Our ref: HE551507-MMSJV-VSS-000-CO-ZH-0065

Monday 18 February 2019

### **A303 Sparkford to Ilchester Dualling scheme**

**Application for a material change to an accepted Development Consent Order to include new land within the scope of compulsory acquisition and remove land from the Order Land**

Drawing Title  
**FIGURE 2.9  
CONSTRUCTION STRATEGY  
KEY PLAN**

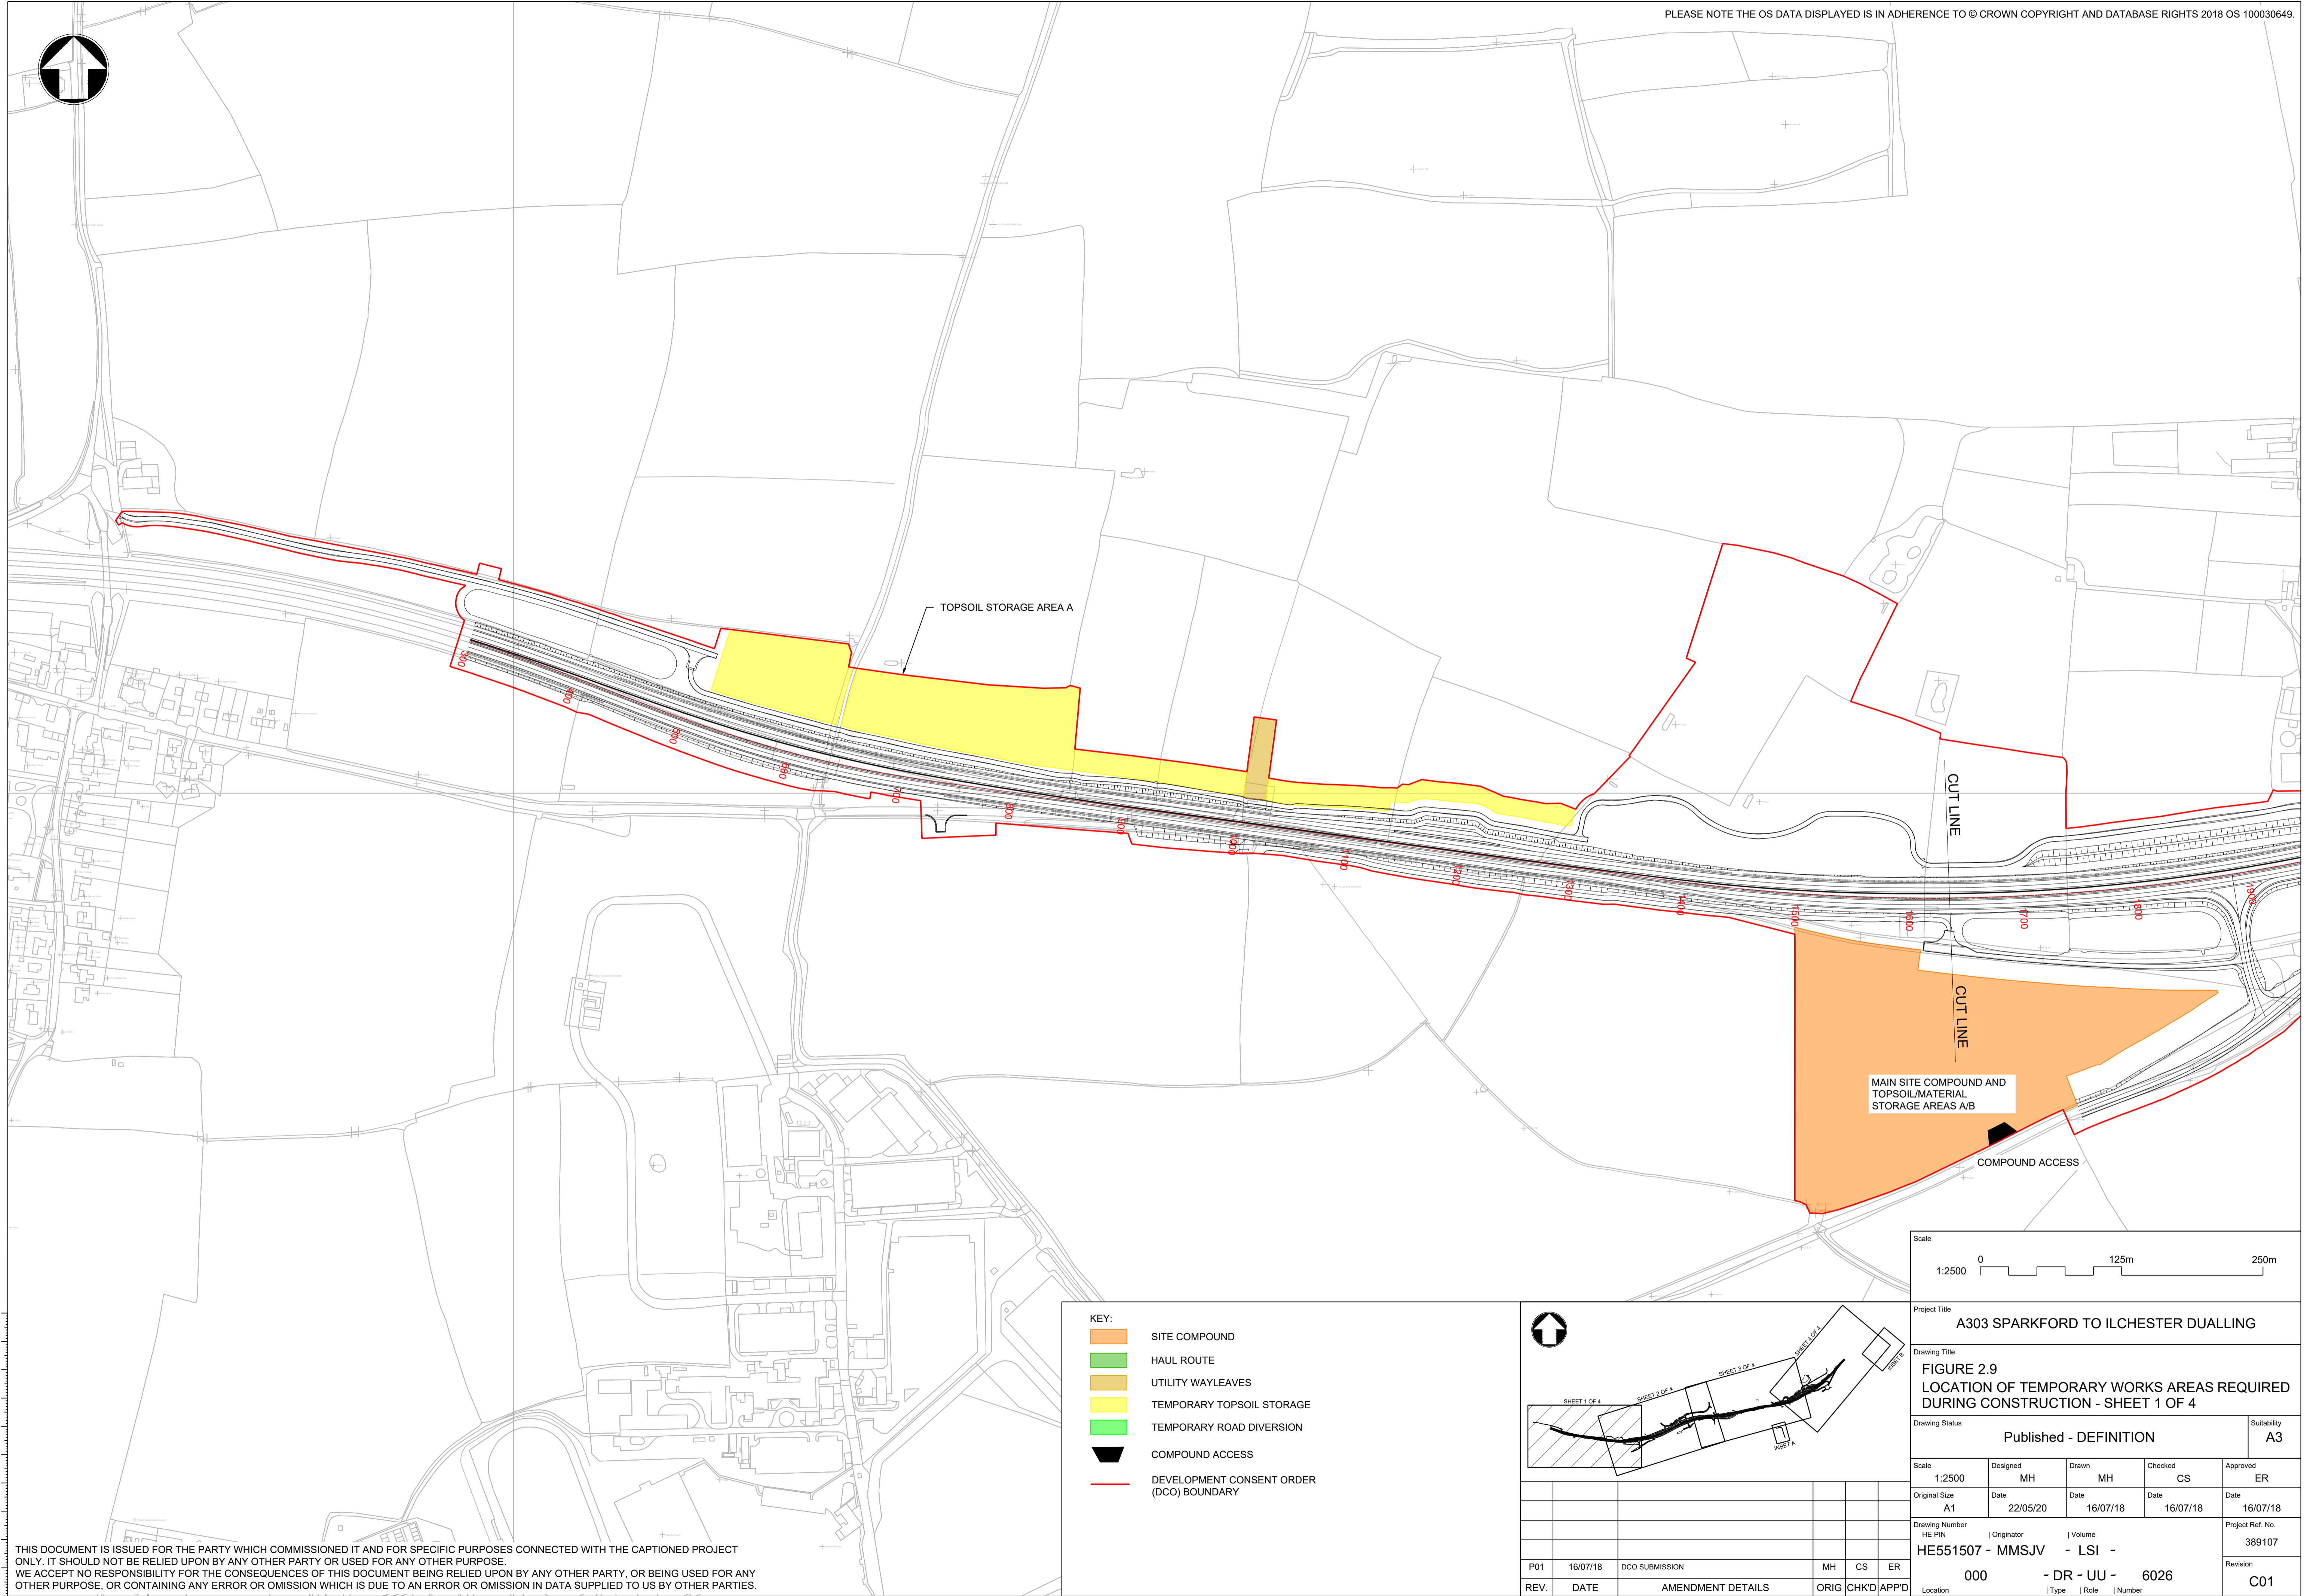
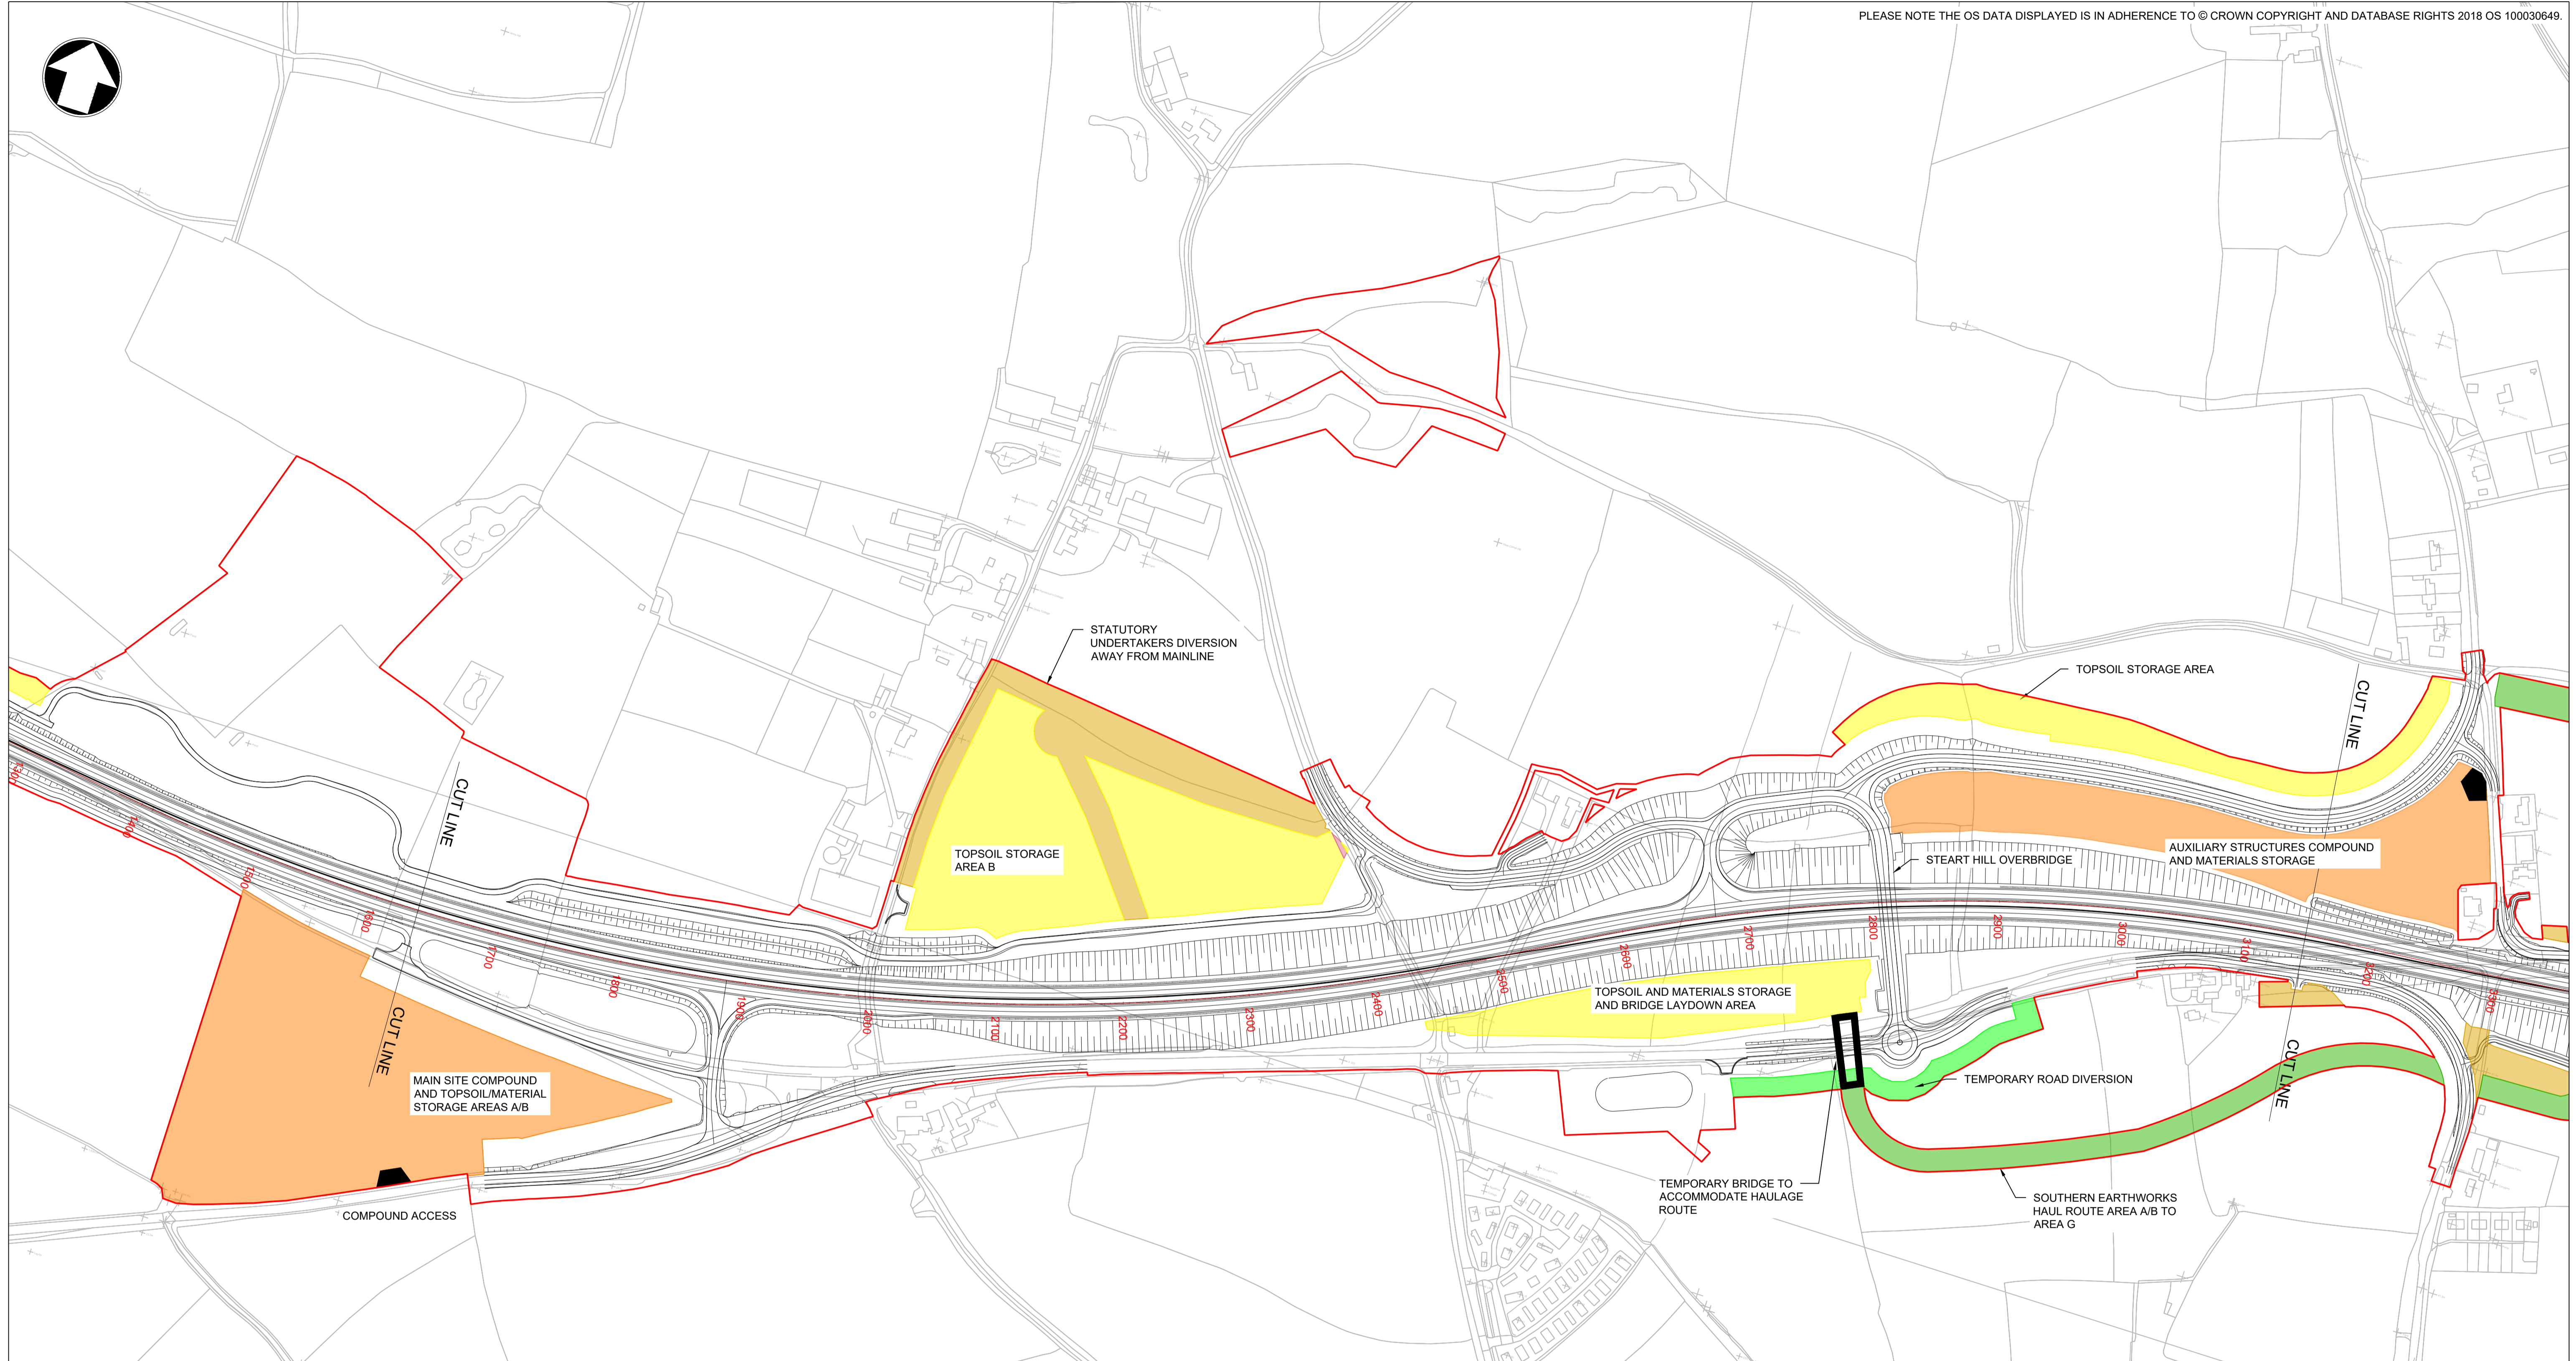
- An amendment to the layout, siting and size of the main construction compound which requires additional land to be added to the land affected by the DCO and which would allow the removal of some of the land currently affected.

- The addition of 98,589 square metres of agricultural land lying to the south of the A303, and the north of the B3151 and marked as plot 2/5e.

- The removal of 47,095 square metres of agricultural land lying to the south of the A303, and the north of the B3151 previously forming part of plot 2/5b, which lies to the immediate east of the land shown as plot 2/5e on the map and to the south of the remaining section of plot 2/5b.

- 2.1 Highways England has been informed by the Defence Infrastructure Organisation (DIO) that much of the land currently identified as the main construction compound is required by them for the installation of new landing lights. Highways England were not aware of the timing or impact of this proposal during pre-application consultation and the conflict of proposed uses has only become apparent following submission of the DCO application.

- 2.2 Highways England have been in correspondence with DIO and have been informed that the proposed landing light works will be carried out between April 2019 and March 2020 and that co-use of the area required for those works is not acceptable to DIO. They advise that for safety reasons they will not agree to any other party working in or moving equipment about near the lights. Given this, Highways England have identified land immediately adjacent to the existing proposed compound area, within the same landownership which it considers is suitable for use as the replacement main construction compound. Highways England therefore requests a change to the red line of the Order to include a new construction compound area at plot 2/5e and to remove part of the existing compound area subject to retention of a strip on the northern edge to provide access creating a reduced plot 2/5b.

- 2.5 The larger size of the proposed new main compound allows the removal of much of plots 5/13b and 7/1b from compulsory acquisition. This area was previously proposed as a secondary construction compound; that has now been amalgamated with the main compound. This change will also assist in addressing objections raised by the landowner of 5/13b and 7/1b that these works would negatively impact on their agricultural operation and use of their unaffected land.
